30 October 2018

16734

RE: PICTON HIGH SCHOOL REDEVELOPMENT (SSD 17_8640) RESPONSE TO SUBMISSIONS

:

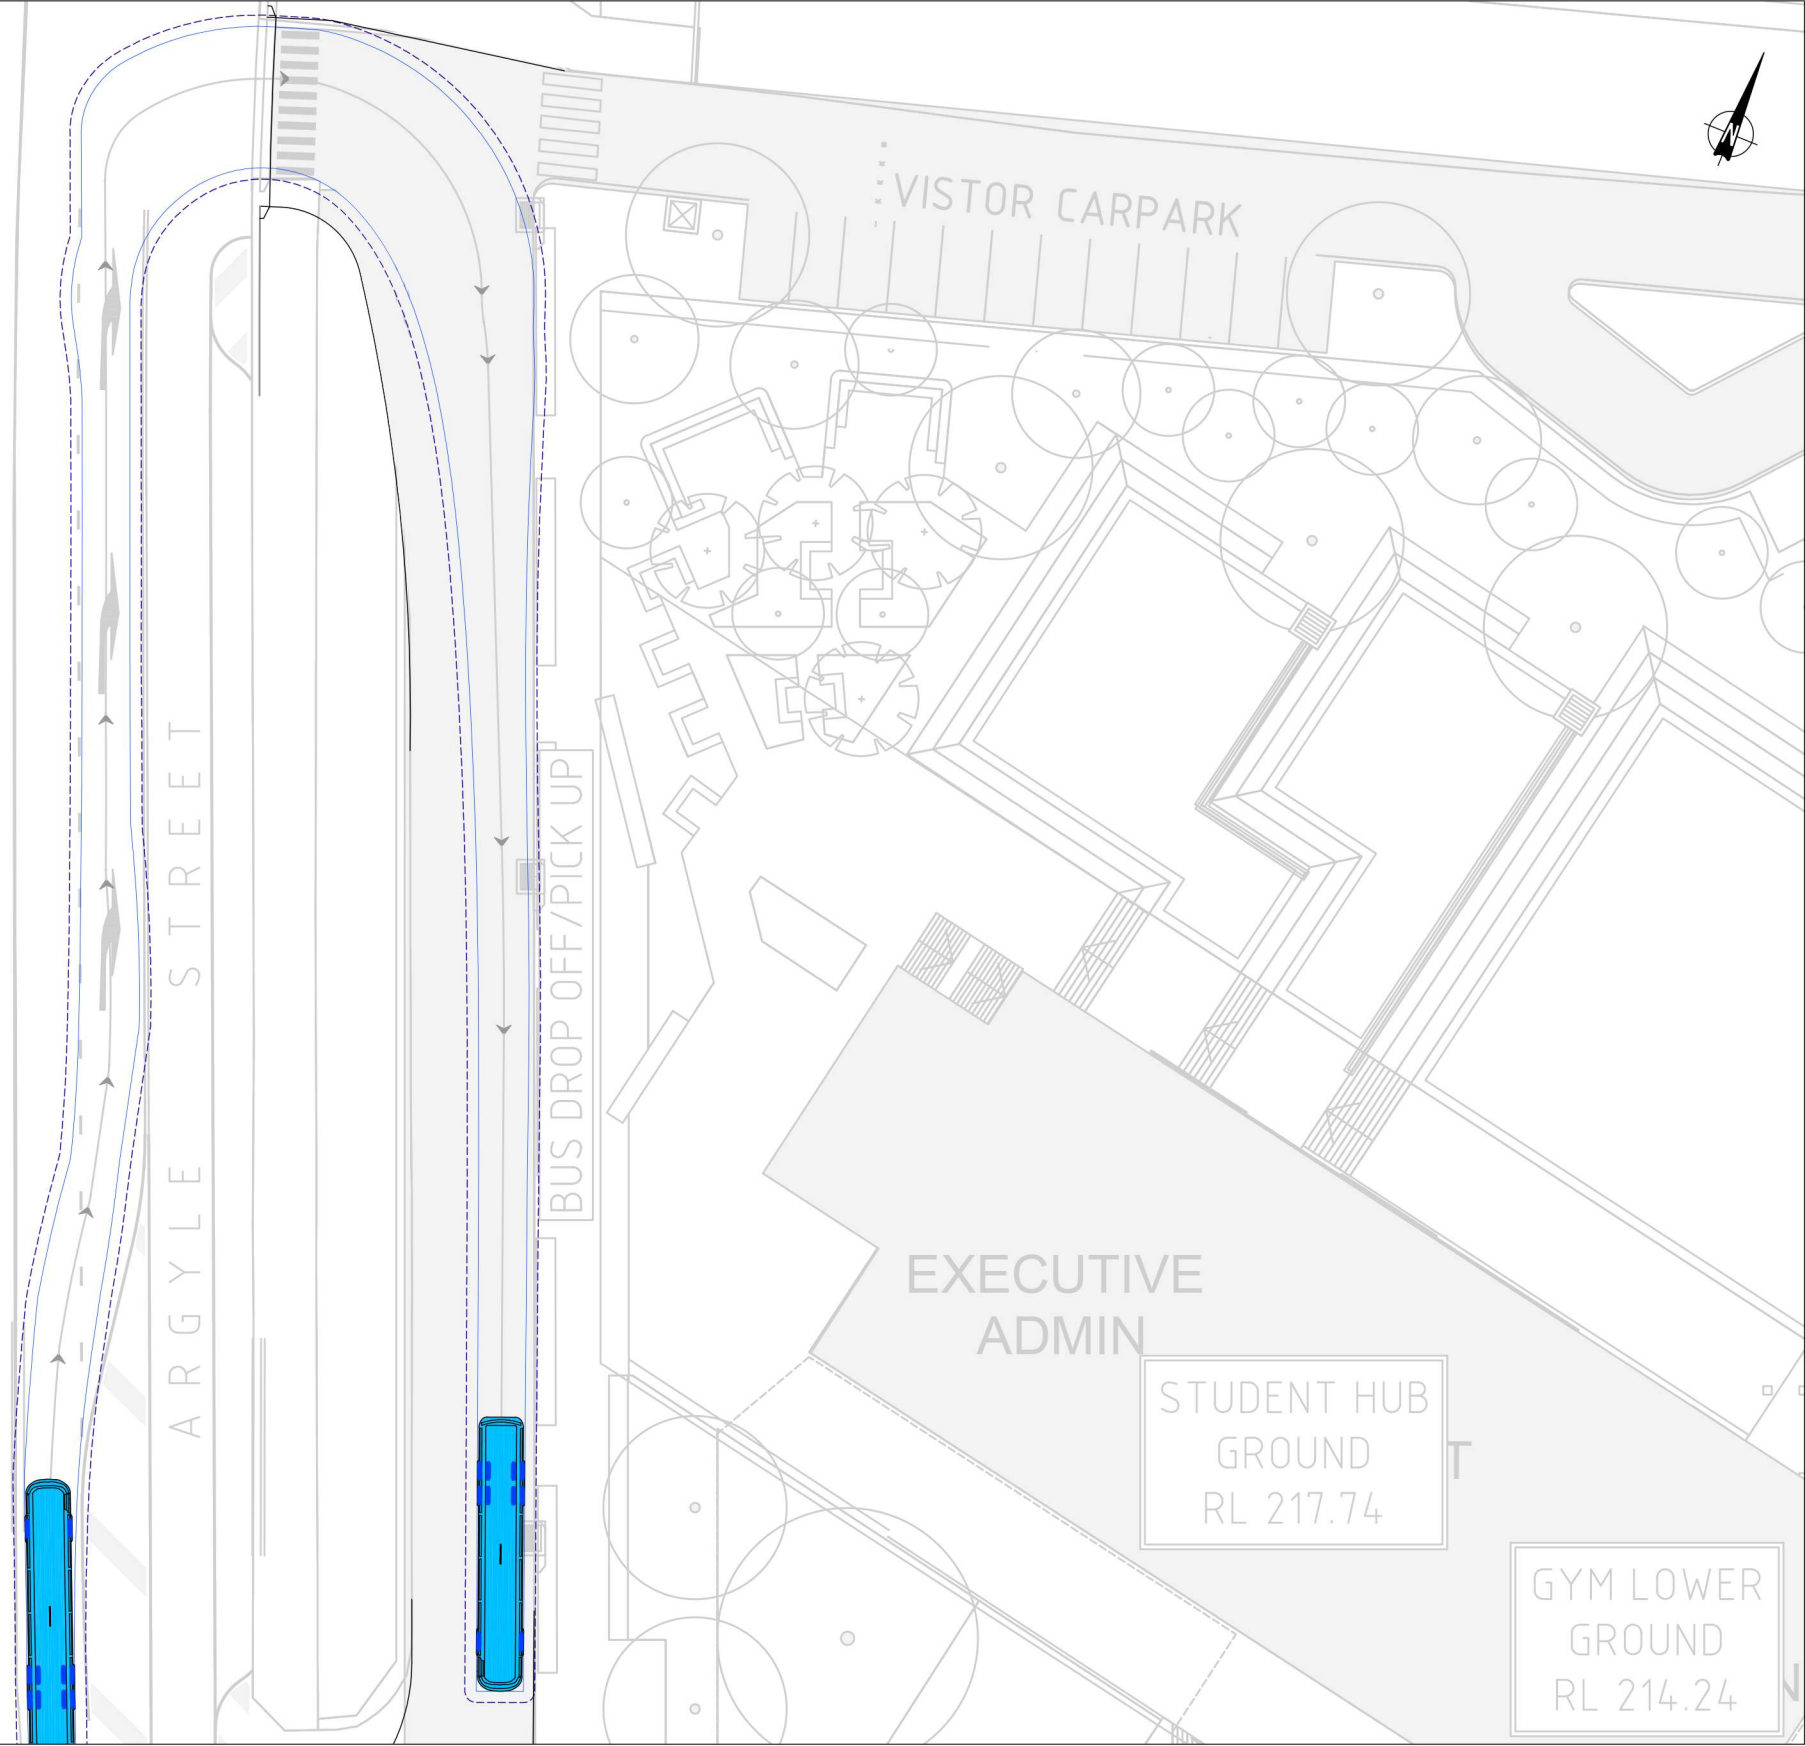
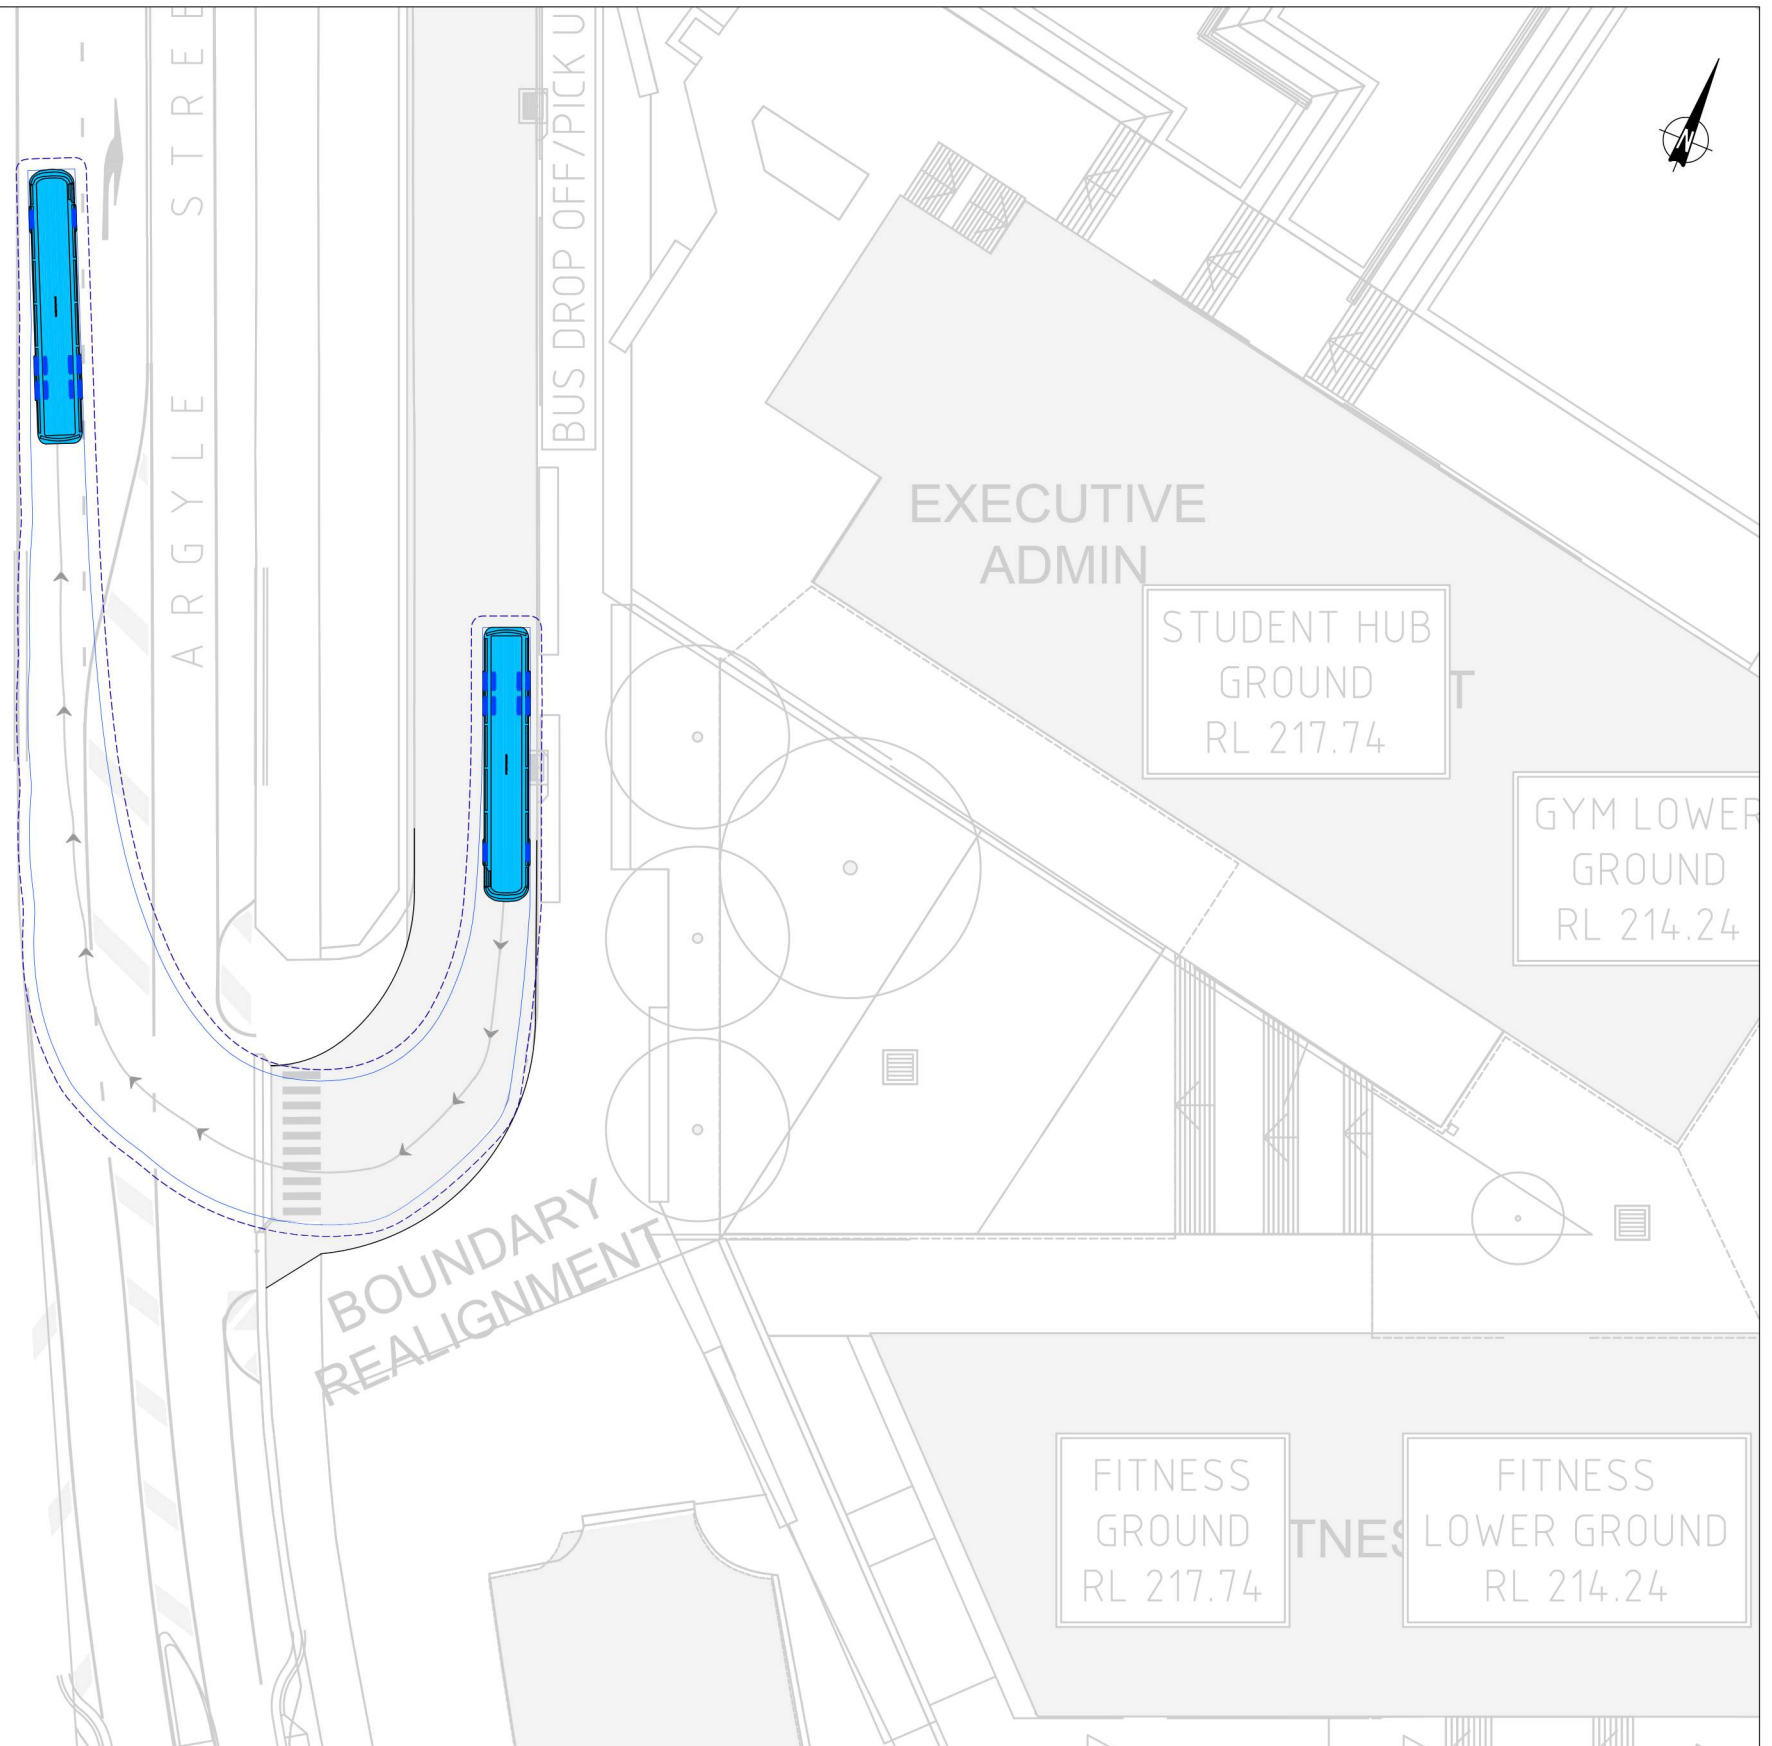
- An assessment of buses exiting the site whilst a bus is parked in the southernmost bus parking bay. In order for a bus to be able to exit the site in this arrangement it is recommended that the kerb line be amended as shown within the relevant figures.

- An assessment of buses accessing the site whilst a bus is parked in the northernmost bus parking bay. The assessment shows that a bus accessing the site from the north can access the site in this arrangement with some modification to the kerb line. However, a bus accessing the site from the south would be required to wait for the bus to exit the bus bay. In this event, the bus would be able to wait on-site or within the right turn bay. To maintain a narrow crossover width at the northern site access to ensure pedestrian safety, and given the infrequent nature of this event occurring, and the low impact of buses waiting for a short period of time before accessing the bus bay, this arrangement is considered to be acceptable.

Accordingly, it is the kerb line has been amended as per the swept path diagrams, as shown in **Figure 1** below.

These proposed recommendations have been made to the architectural drawings at **Attachment B**.
